PLANNING CONSULTATION RESPONSE

Application No	2025/1076
Proposal	Erection of 5no. dwellings
Address	Bell Yard, Wells Street, Cudworth, Barnsley, S72 8DP
Date of Consultation Reply	13/04/26
Consultee	Highways Development Control

BLOCK PLAN
SCALE 1:500 AT A3

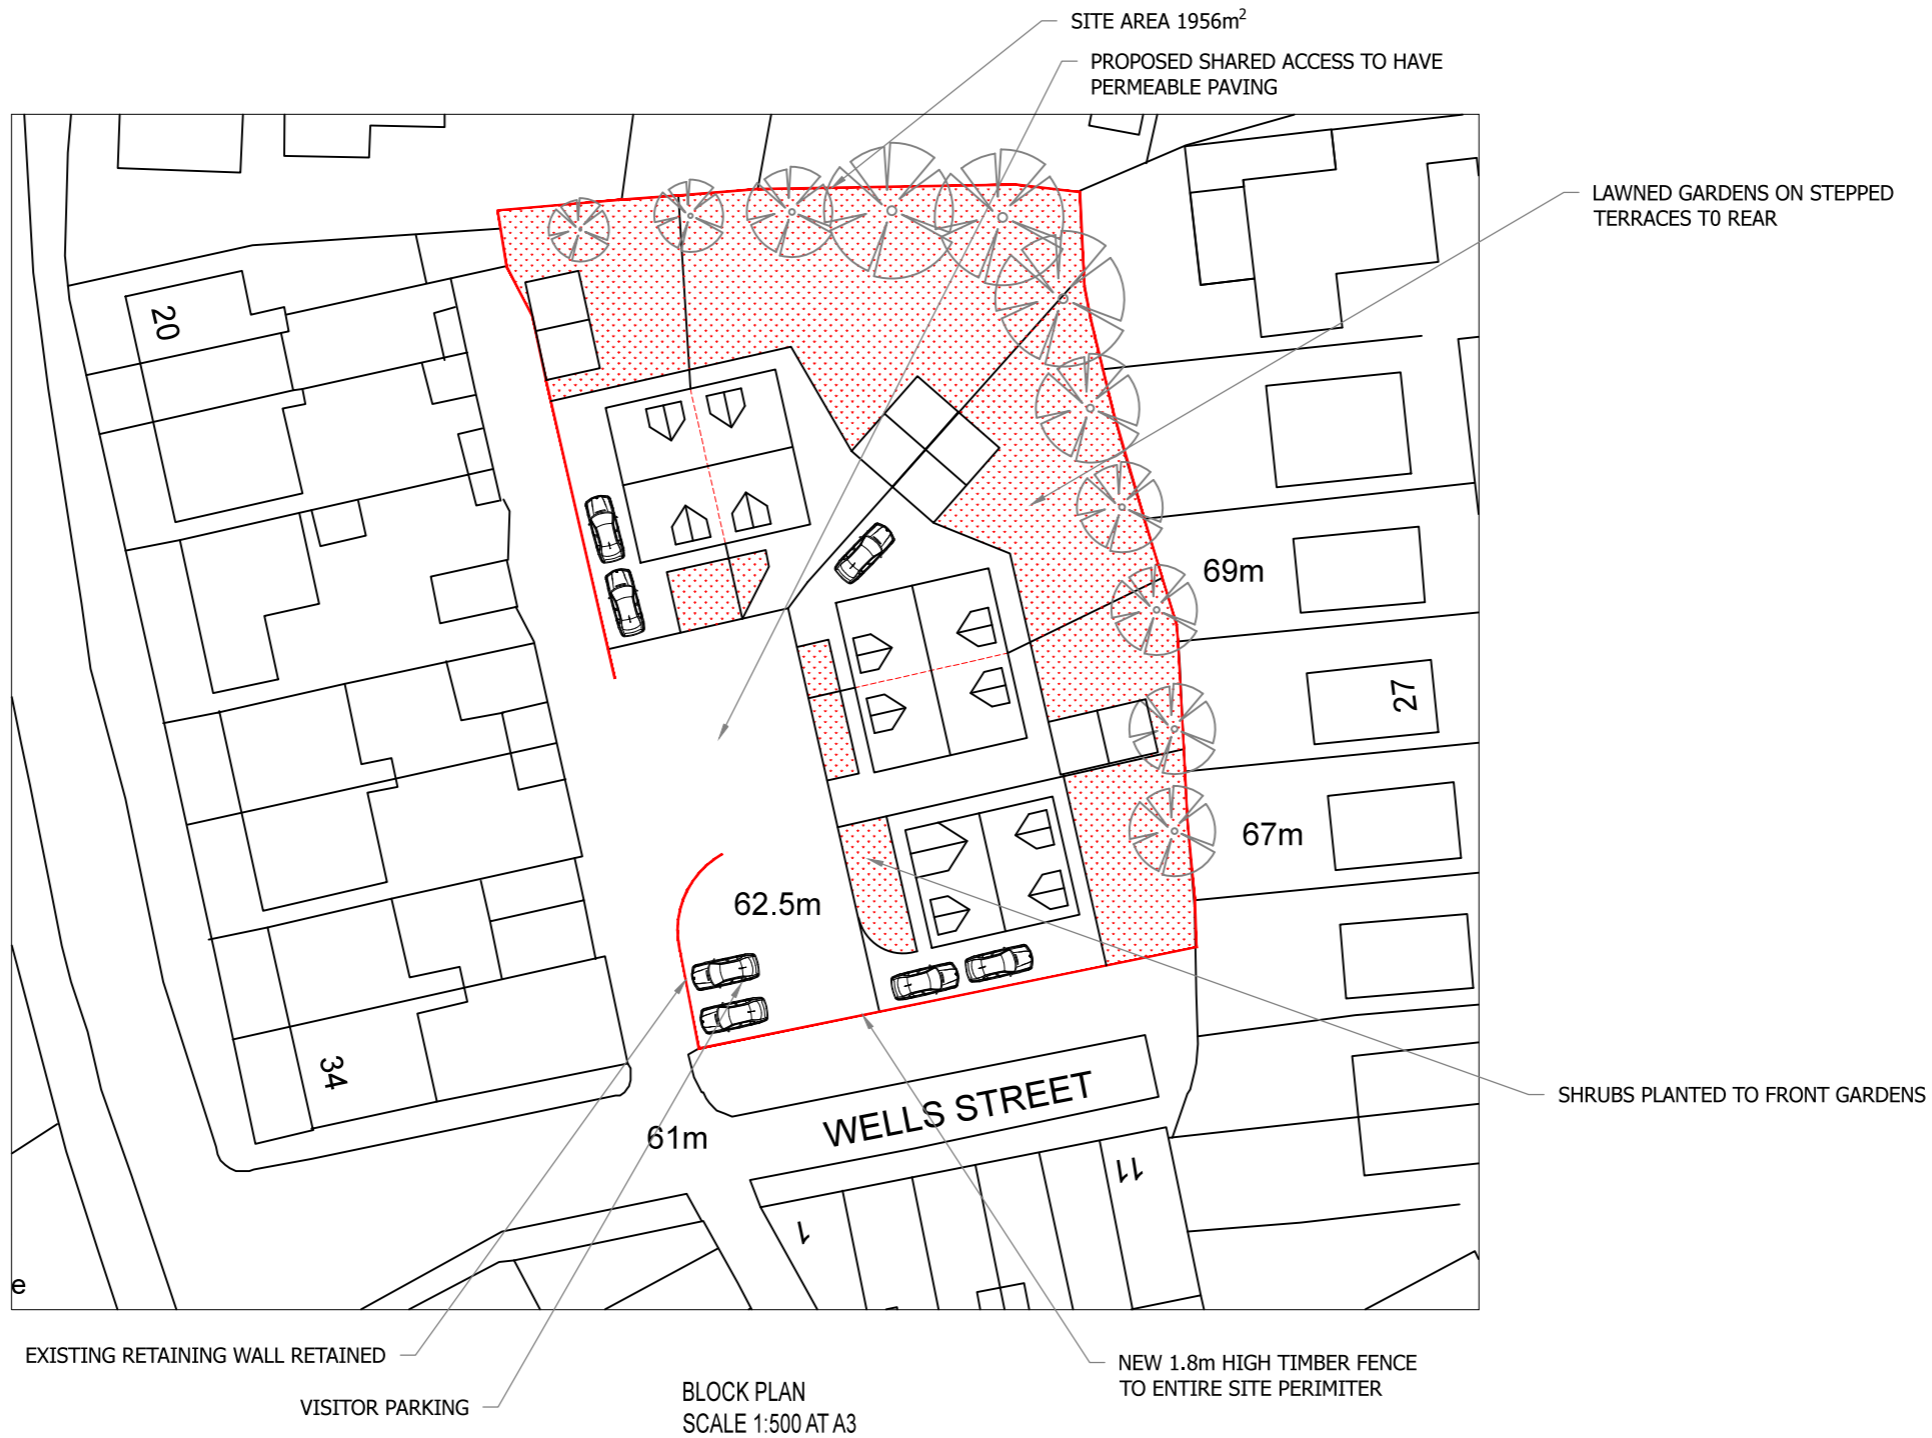
The site is quite constrained and is bounded in part by a retaining wall directly adjacent to the highway. From both the drawings and the site photos, this wall clearly forms a structural boundary and is likely to be affected by any additional loading from the development. This could include loading from vehicles, parked cars, and any changes in levels or surfacing within the site.

Having consulted directly with our Structures Section, we have been advised that the applicant would need to demonstrate that the existing wall is capable of accommodating any increased loading from both the proposal buildings and any vehicles that may park or delivery vehicles that may use the surfaced areas adjacent to the retaining wall. Without this information, there's a risk to the integrity of the wall and to the safety of the adjacent highway and its users.

In terms of the layout, the general arrangement is acceptable in principle, however I have some concern with the proposed shared driveway serving the two most central plots. This appears to pinch down to around 2.3m between the corners of the buildings and the proposed boundary line, which is very tight and would likely cause issues in day-to-day use if the boundary would be a physical feature. It would be helpful to understand whether this is intended to be an open plan shared surface or whether any boundary treatments are proposed.
